**OXFORDSHIRE COUNTY COUNCIL'S RESPONSE TO CONSULTATION ON THE  
FOLLOWING DEVELOPMENT PROPOSAL**

**Application no:** 15/00153/REM

**Proposal:** Reserved Matters to Outline application 10/01642/OUT - Village green including sports provision.

**Location:** Heyford Park Camp Road Upper Heyford Bicester OX25 5HD

Village Green Landscape Proposals
Scale 1:200

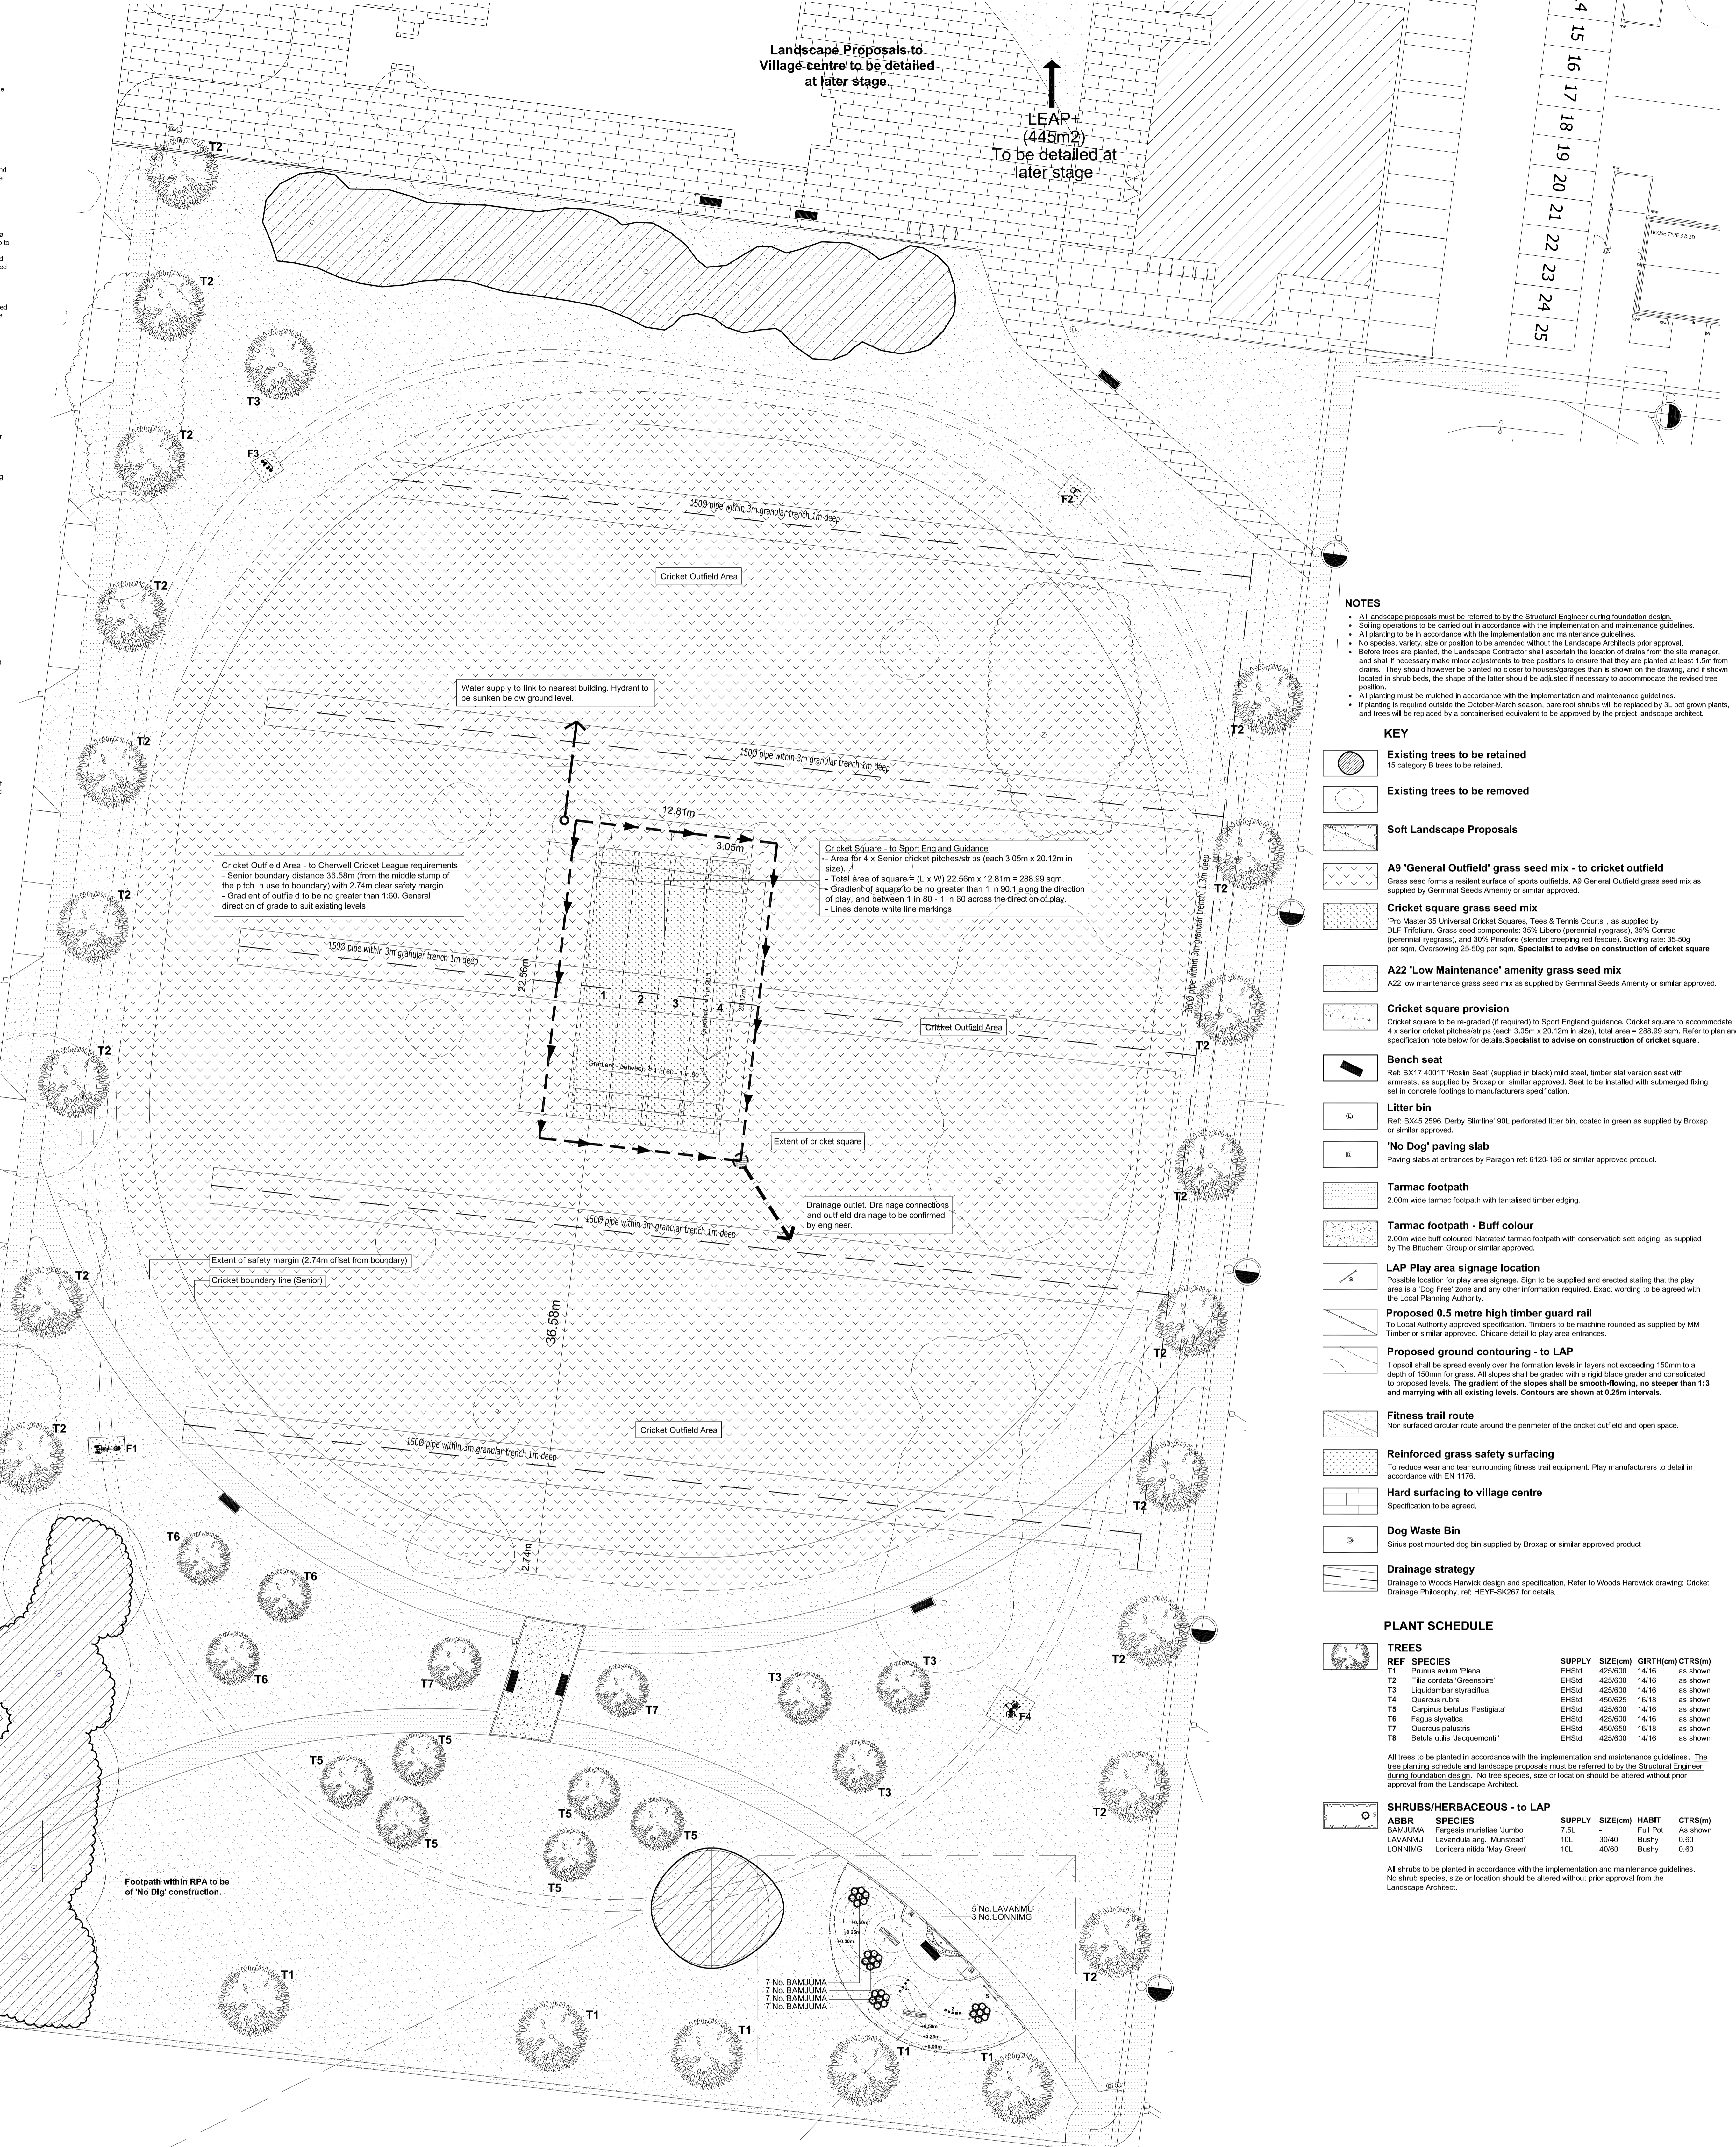
The planning application does not include any details of proposed parking provision for the village green in general and for cricket matches in particular. The site location plan and the more detailed plan do show some spaces immediately to the north of the village green, although it is unclear whether any or all of these will be available to users of the village green. It is worth noting that the demand for parking during a cricket match could be significant with players, officials, spectators and caterers all likely to generate some demand. Details of parking proposals, together with some assessment of their adequacy, will be required.

- D18 Plan of car parking permission.
